ENVIRONMENTAL STATEMENT - VOLUME 3 - APPENDIX 4.2

Environmental Statement Scoping Opinion Responses

Drax Bioenergy with Carbon Capture and Storage

PINS Reference: EN010120

Plate 2.1 - Process Block Flow Diagram for the Proposed Scheme

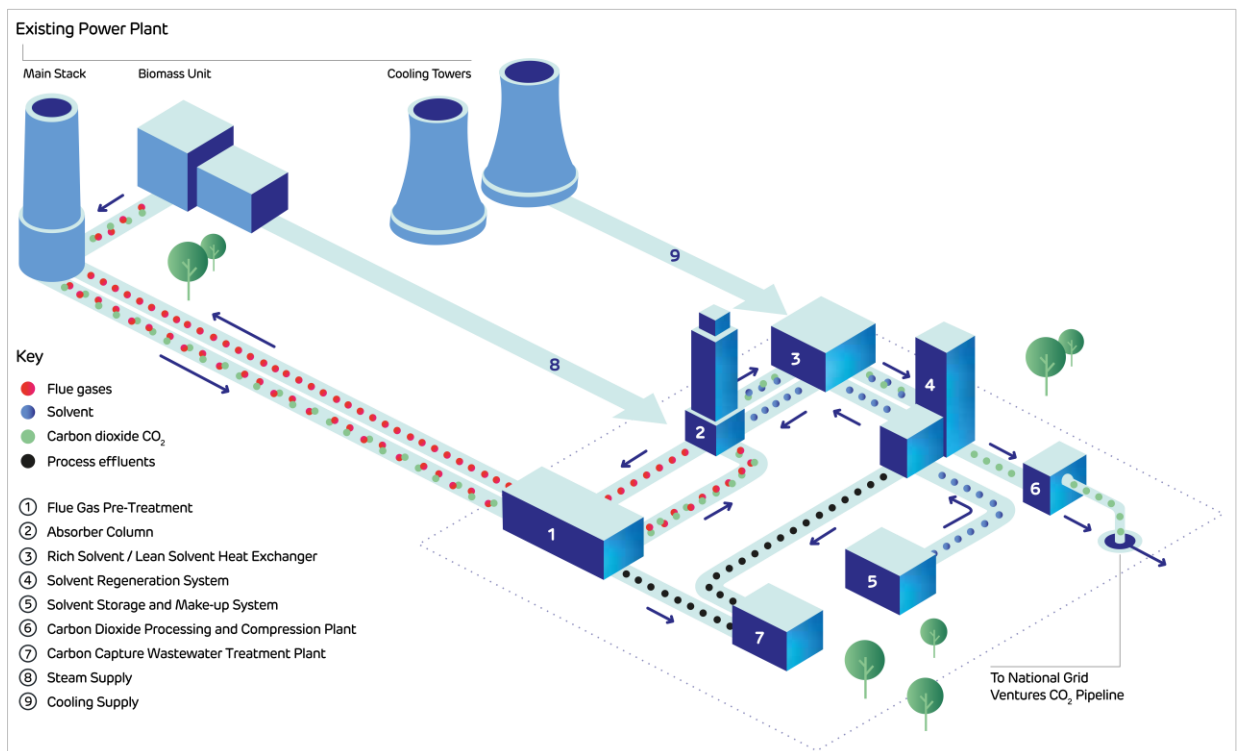
2.3.12	The Inspectorate notes that the Scoping Report provides a generic diagram of the carbon capture infrastructure (see Figure 2.2, Scoping Report). The ES should include a detailed process diagram that clearly identifies the components of the proposed carbon capture technology and is consistent with the description of the Proposed Development provided in the ES. This must be consistent with the description of development in the DCO.	Plate 2.1 (Process Block Flow Diagram for the Proposed Scheme) in Chapter 2 (Site and Project Description) provides a schematic to show the BECCS process in line with the description set out in the chapter. This is consistent with the description of the development in the dDCO (document reference 3.1) and supporting plans (document reference 2.1 – 2.6).
